ADC PARKS & GREENSPACE ARBORICULTURE

PLANNING APPLICATION: AL/41/15/T

ADDRESS: Westergate Mews Nyton Road Westergate PO20 3YP

BRIEF DESCRIPTION: Reduce tips of branches extending over car park & driveway to North by 2- 3m to 1 No Holm Oak tree.

Westergate Mews Appendix 5 - survey plan

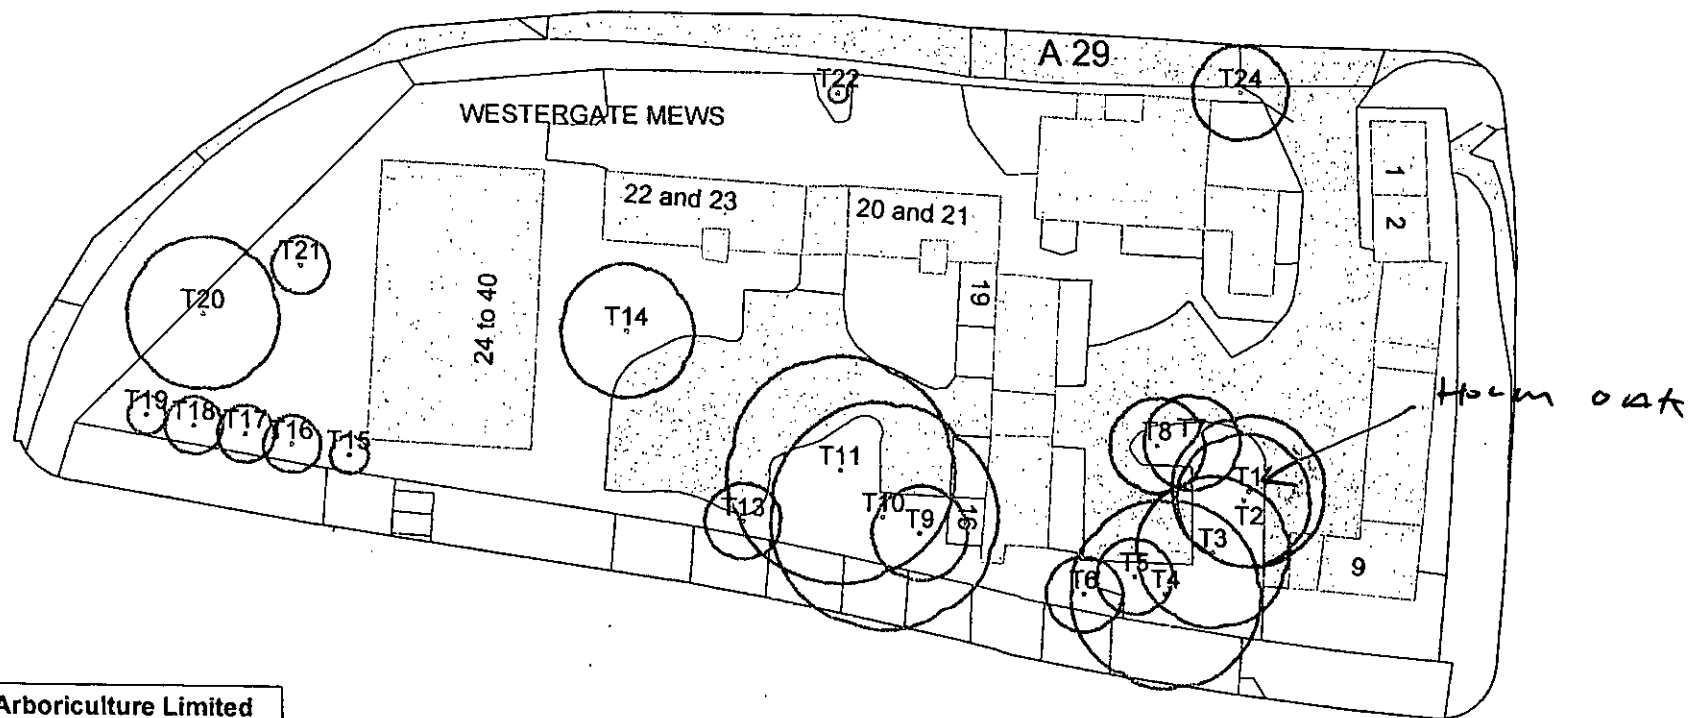
- The tree highlighted in the application is located along the main driveway to Westergate Mews. **T1** is visible from the main highway (A29) outside.

- From the site inspection, it is quite apparent there is a large wound present at 3.5 meters height on the main stem of **T1**. The applicant has stated there has been a climbing inspection completed of this wounding, which has found

- The applicant has applied to reduce the northern flank of **T1** by no more than 3 meters. From the site inspection it is also clear that the Northern flank of **T1** has already had a previous reduction. These previous reduction/s does emulate the applied for reduction.

- The applicant has justified the need for this pruning operation, as 'to further reduce likelihood of branch or stem failure resulting in injury or damage to property'. I would agree with this statement as from the site inspection it is clear that the basal area of **T1** has tapered heavily. This formation could lead to spiral cracks, hazard beams, and ribbing forming throughout the main stem. The applicants suggested reduction of 3 meters to the northern side, is likely to reduce the potential systemic failures occurring.

- **I would have no objection to the proposed operation** of a reduction to the northern side of **T1**, of no more than 3 meters.
- **The following conditions must be adhered to;**

All side branches to be retained should be at least **1/3rd** in diameter of the removed branch. Pruning cuts must be flat and smooth, kept as small as possible by cutting at an optimum angle and should not exceed **100mm** in diameter.
